DRB Application No.: _____ Project # 1008695
Project Name: Remodel Exist. Truck Wash Facility
Agent: BILL BURK, ARCHITECT Phone No.: 292-6566

DEVELOPMENT REVIEW BOARD MEMO

**City of Albuquerque
Planning Department
Inter-Office Memorandum**

SUBJECT: Project # 1008695

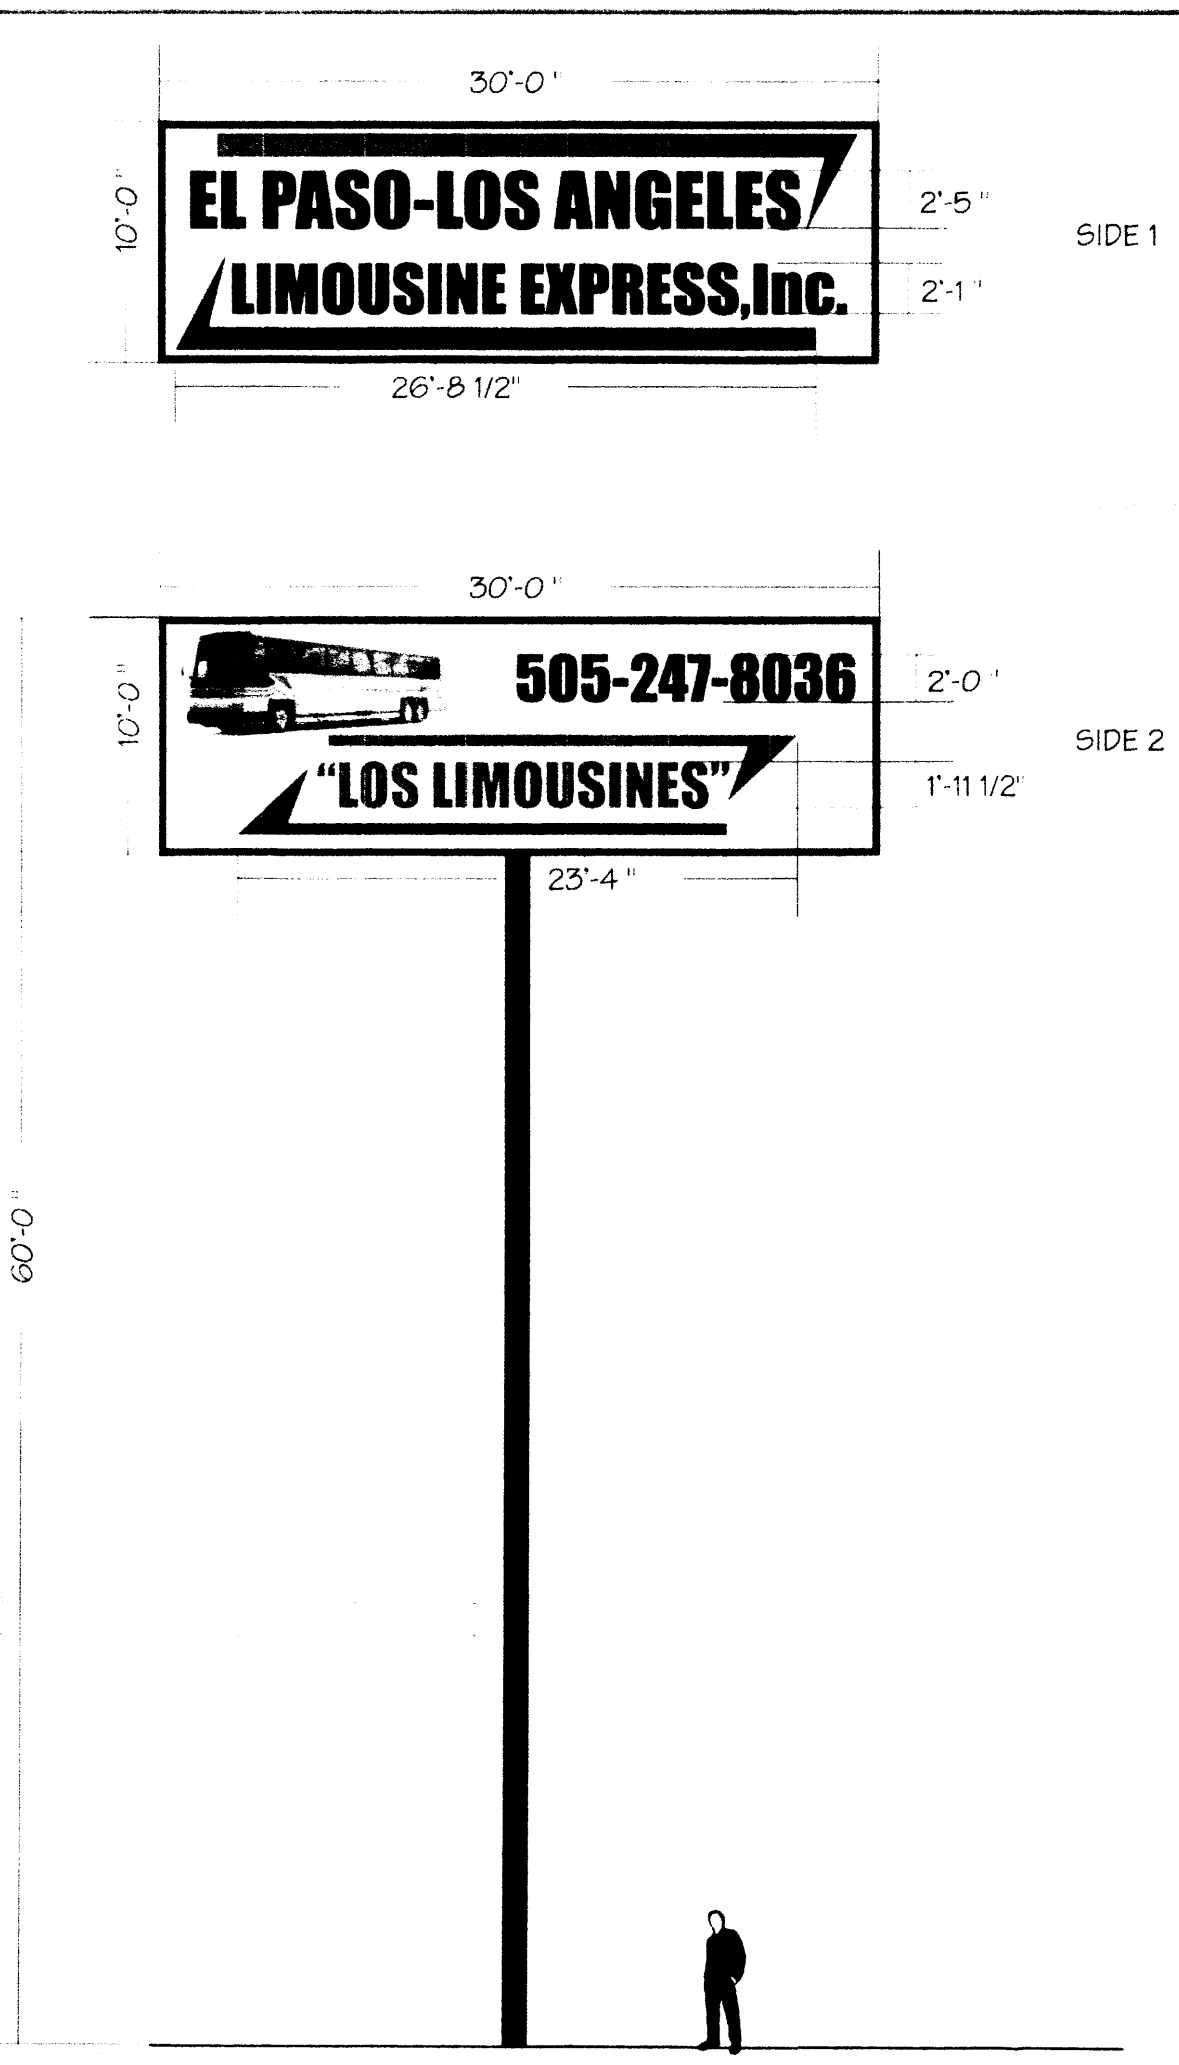
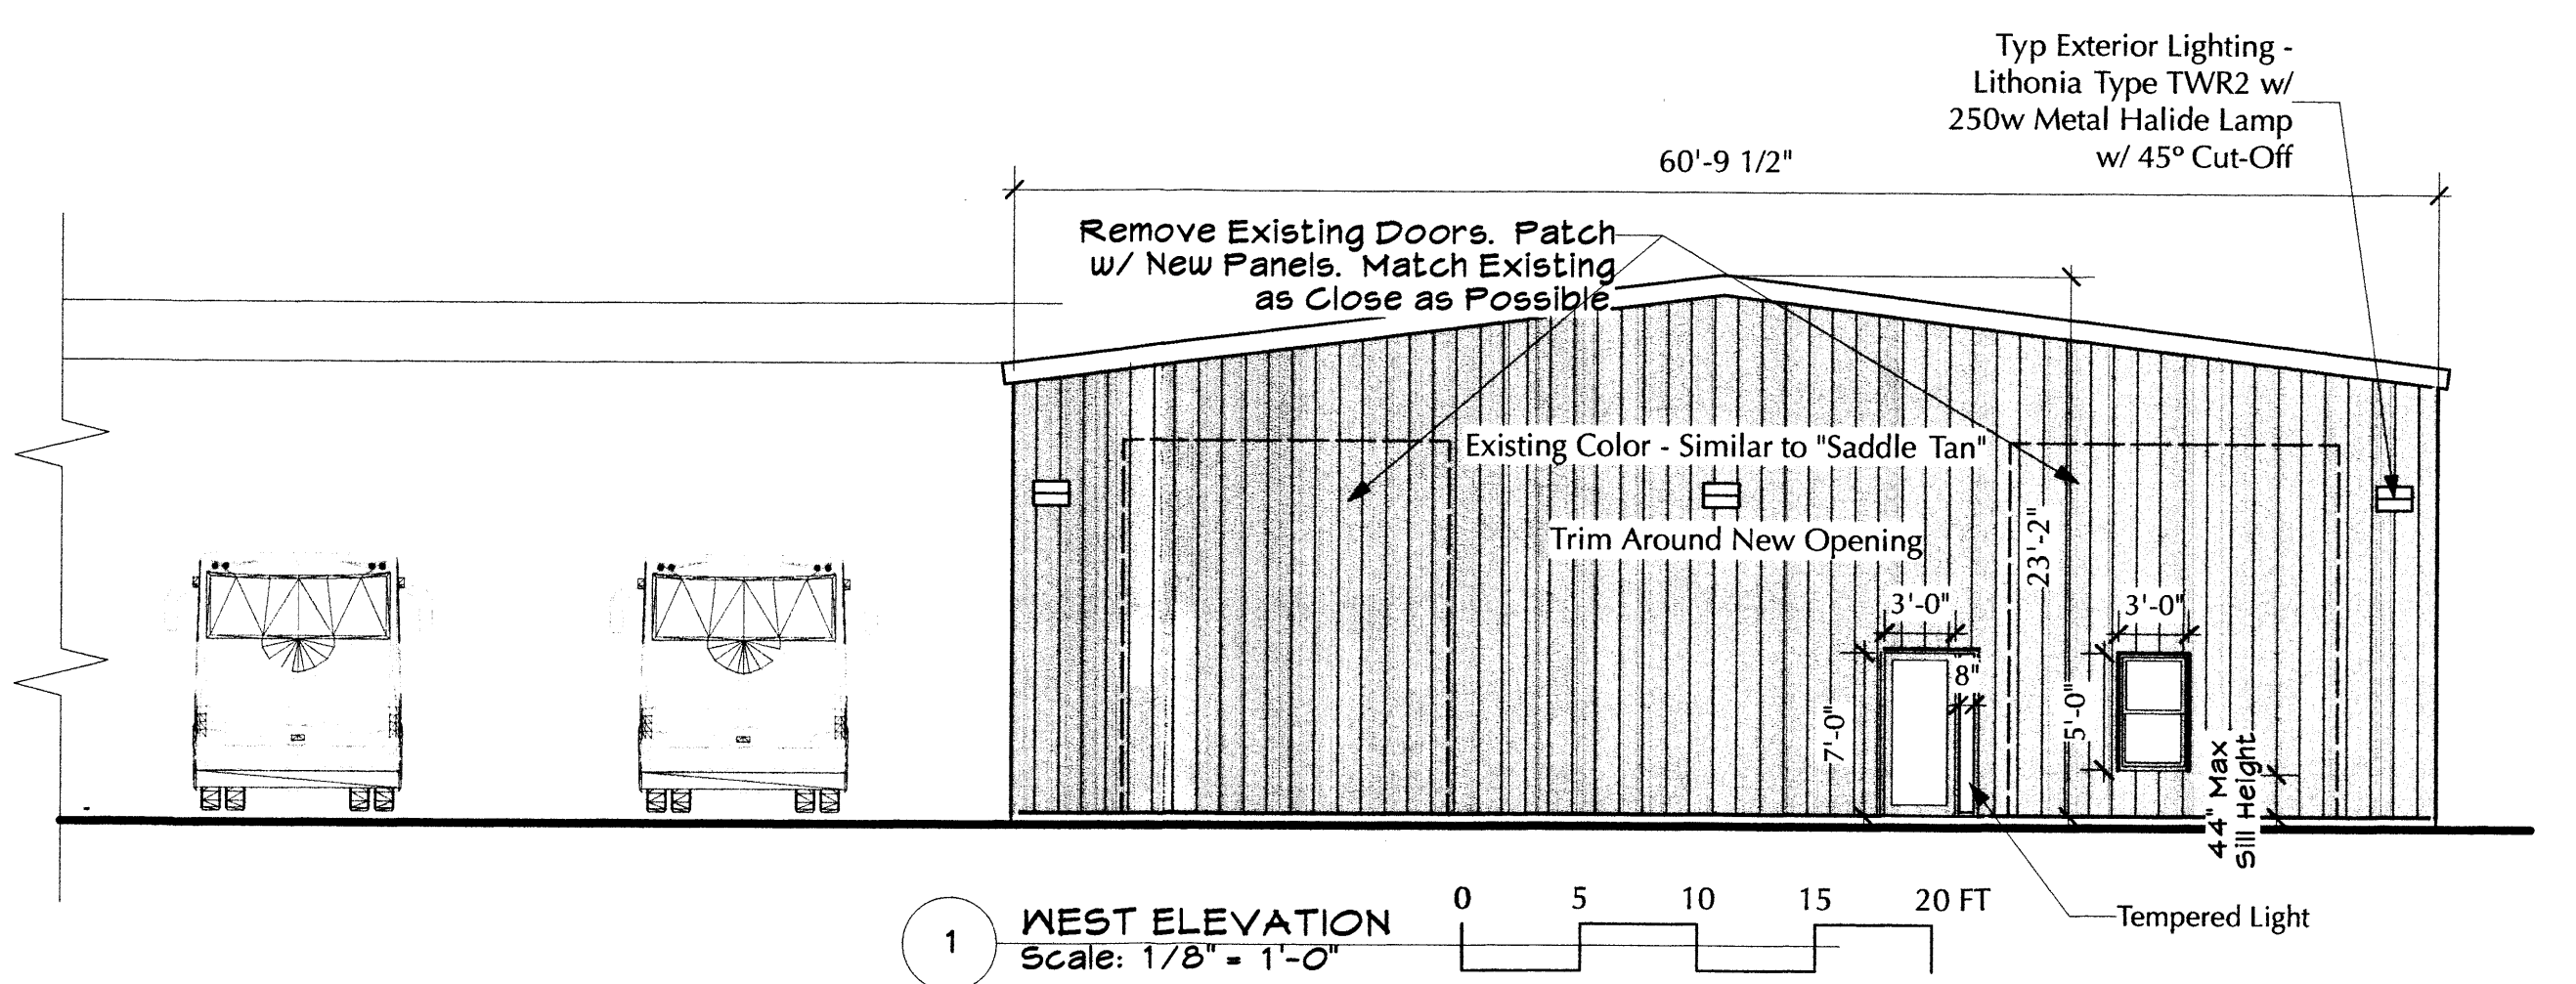
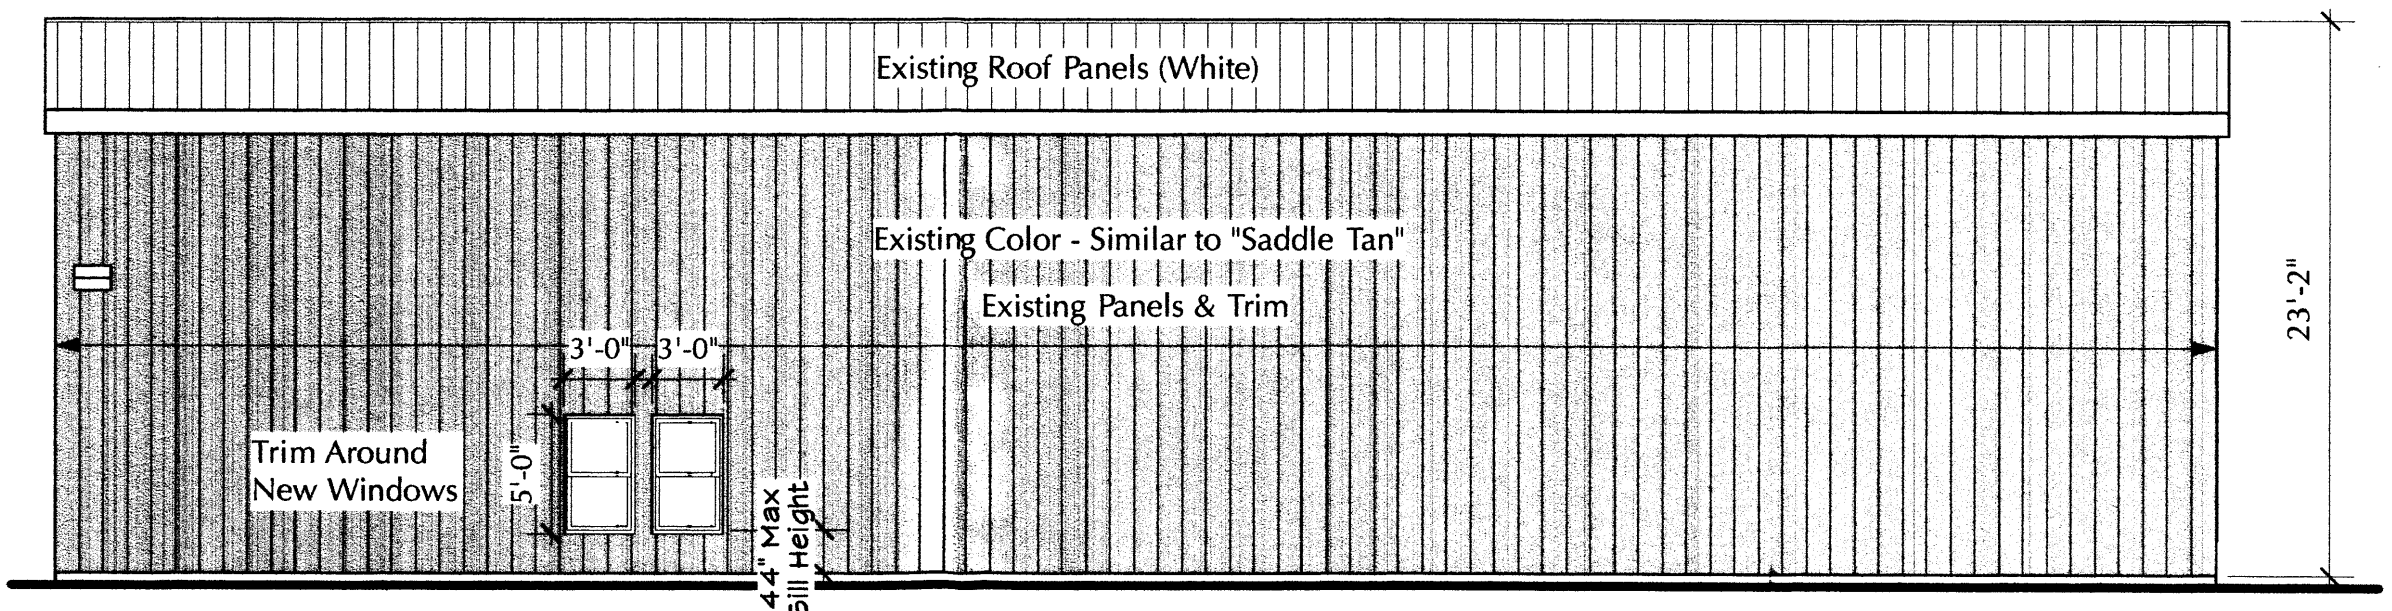
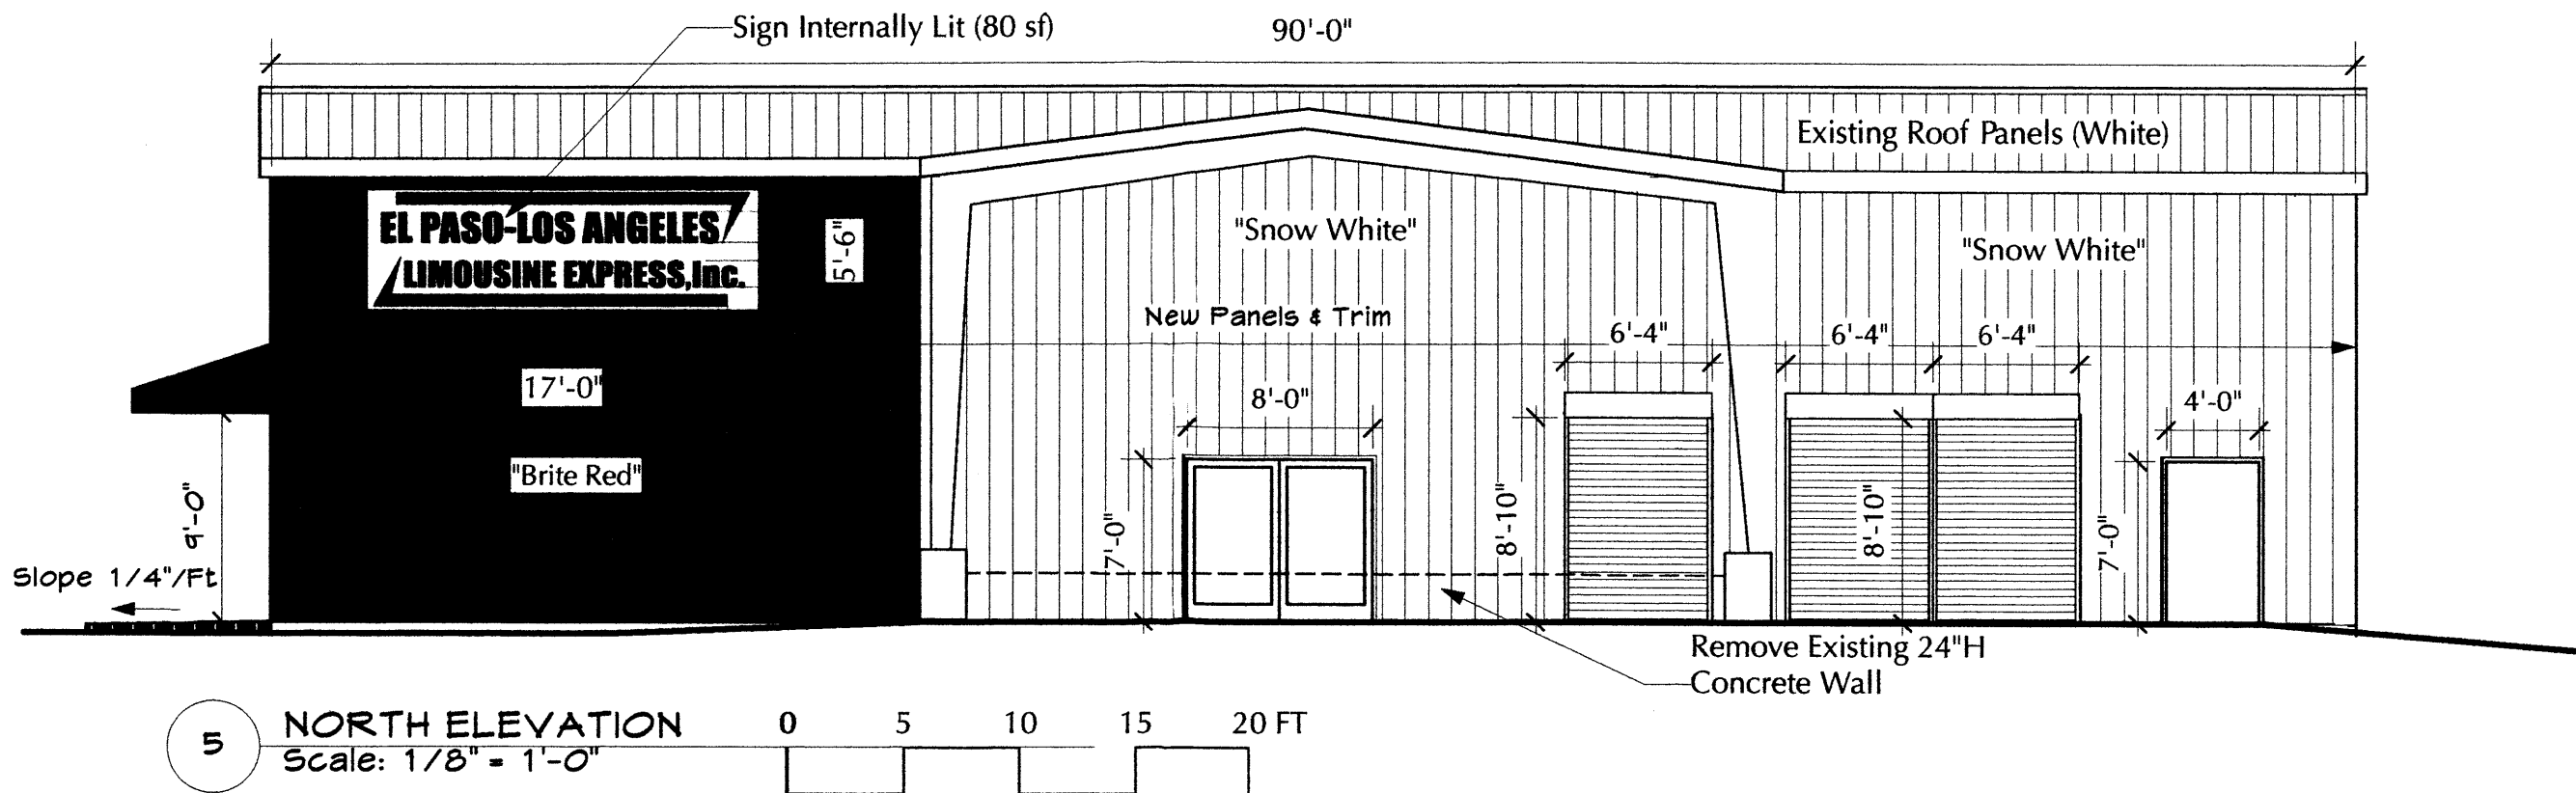
The applicant has generally satisfied the EPC conditions of approval for the site development plan for building permit. Sheet 2, Architectural Elevations, as reviewed and approved by the EPC, was not *included in this submittal. This sheet needs to be added to the final site development plan, which should be numbered accordingly.* Staff has the following comments regarding EPC Conditions of Approval:
